HOMESTEAD NORTH AT STERLING RANCH

EARLY GRADING AND EROSION CONTROL PLANS

PCD-ENGINEERING REVIEW COMMENTS
IN BLUE BOXES WITH BLUE TEXT

PCD FILING NO.: SP-20-008

SHEET 3 OF 10
JOB NO. 25188.00

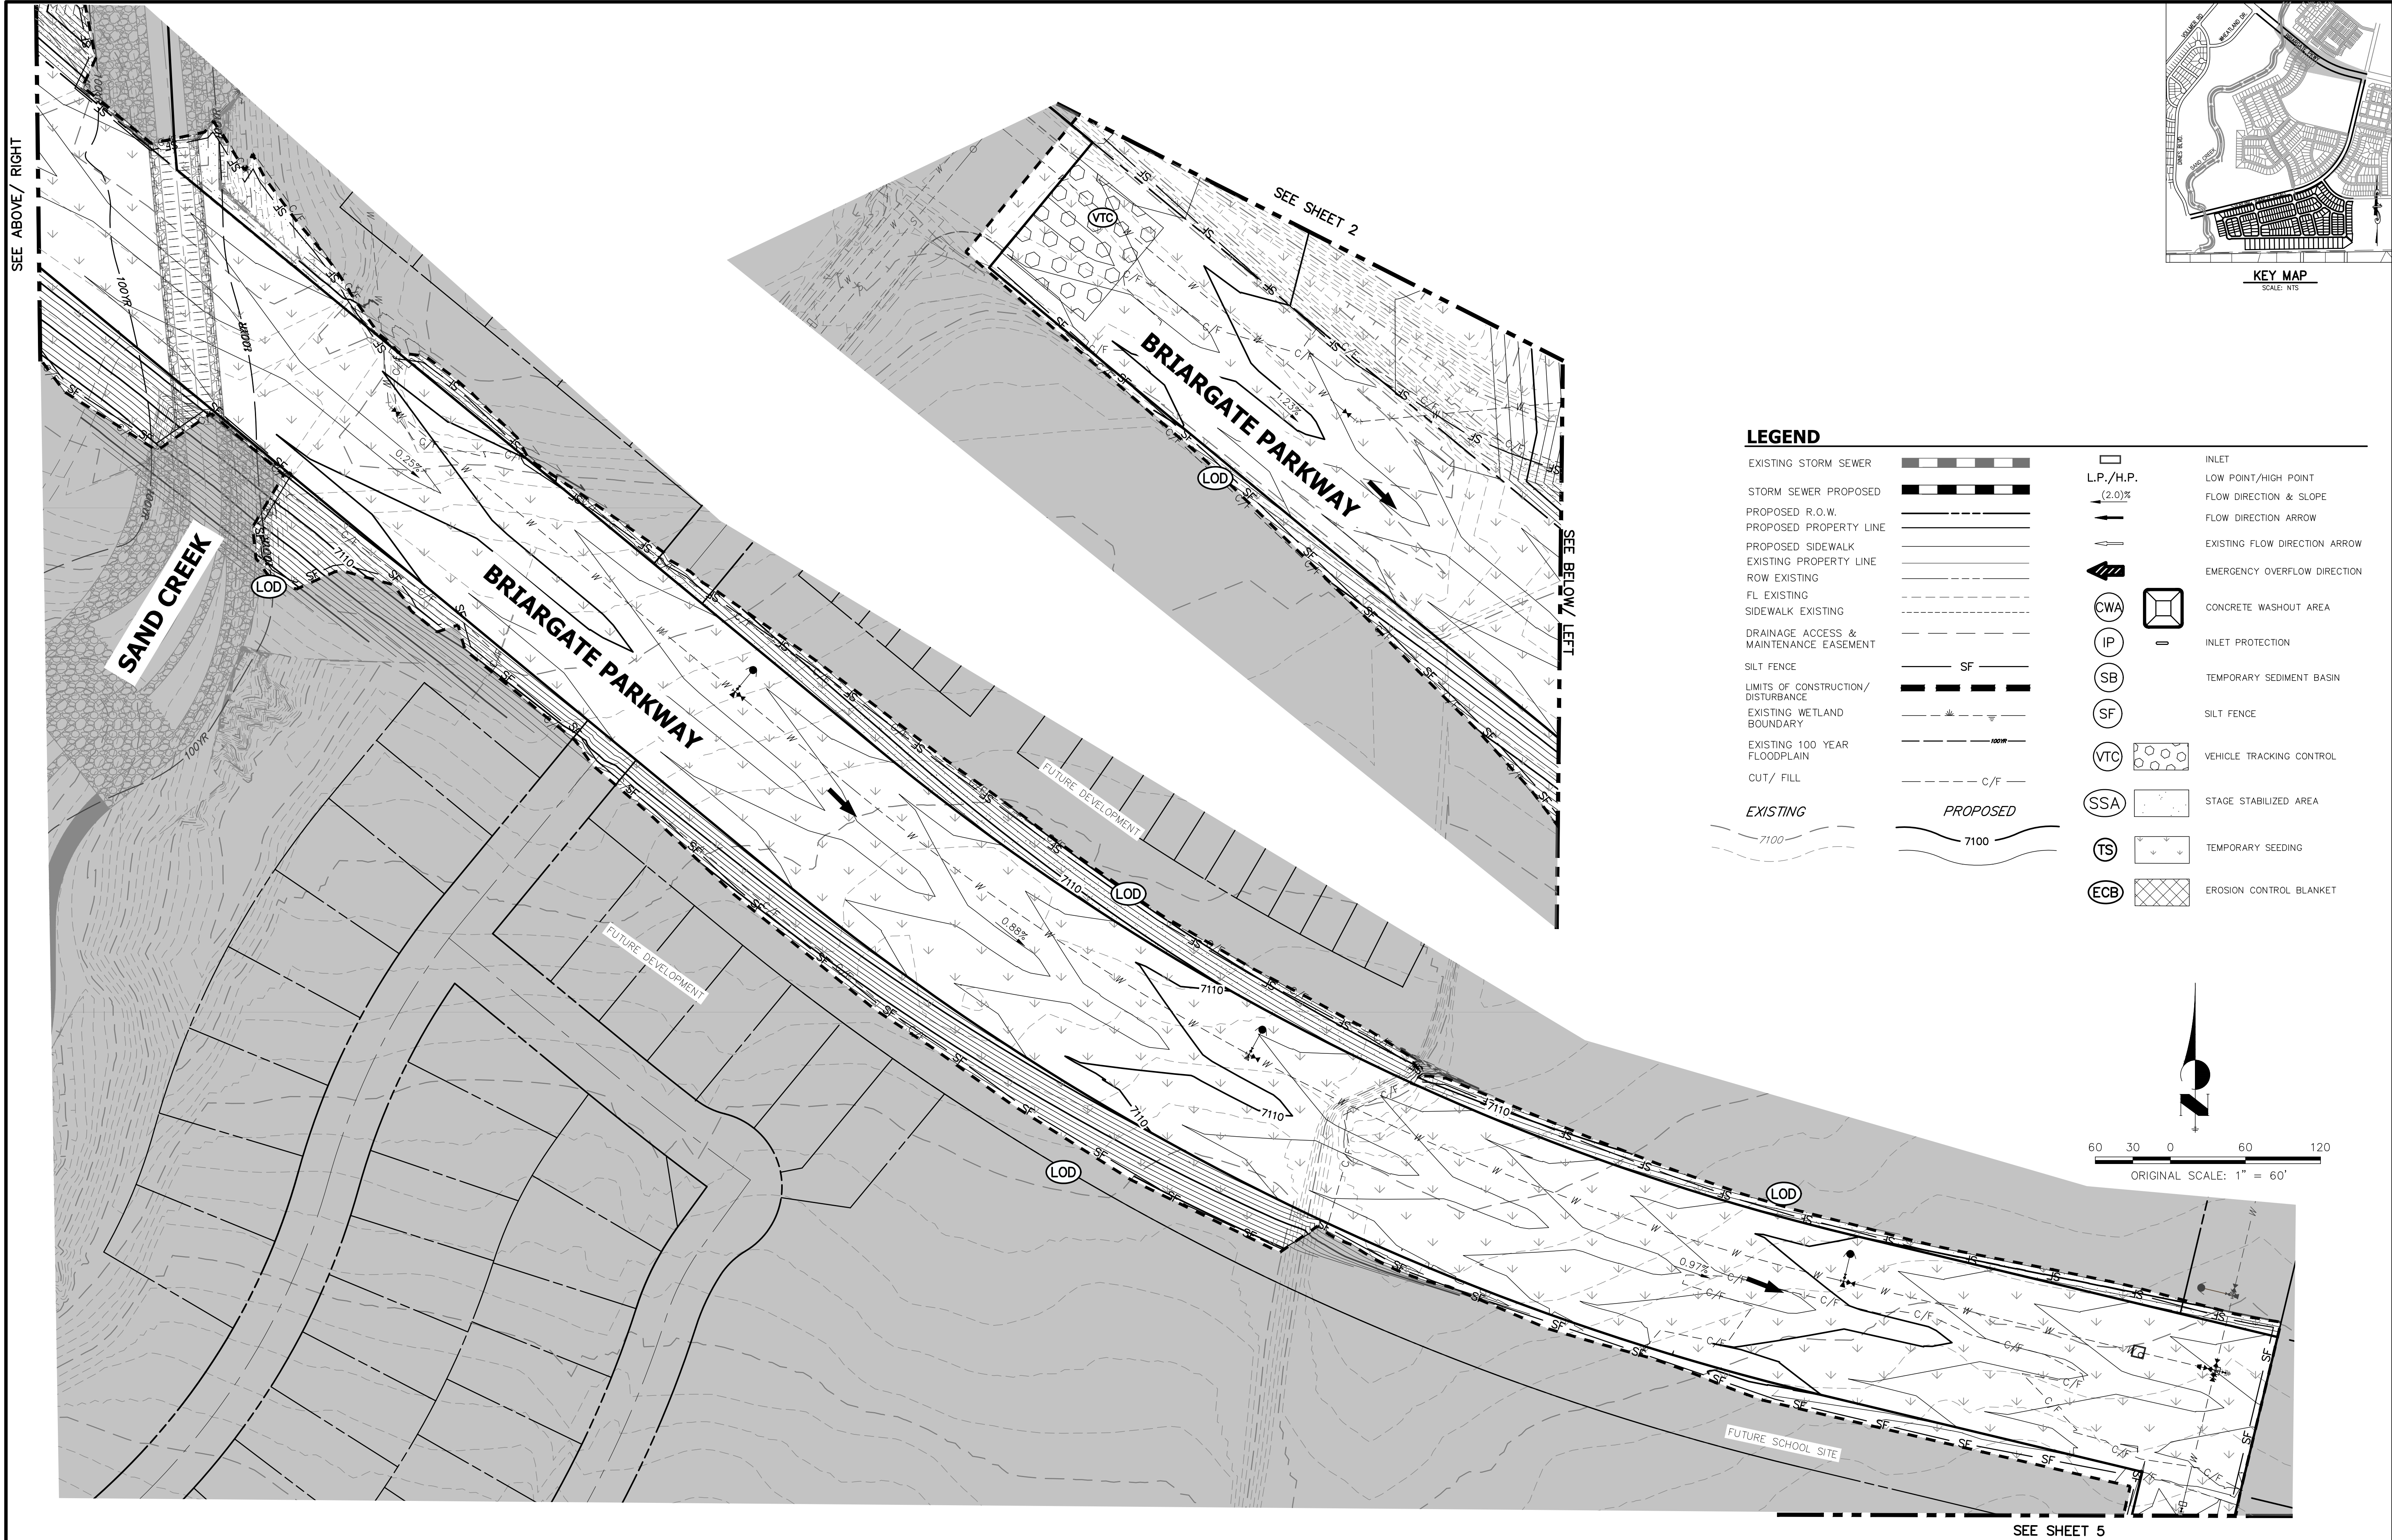
Provide erosion protection to bottom of channel

JR Response: Added protection to the bottom of the channel
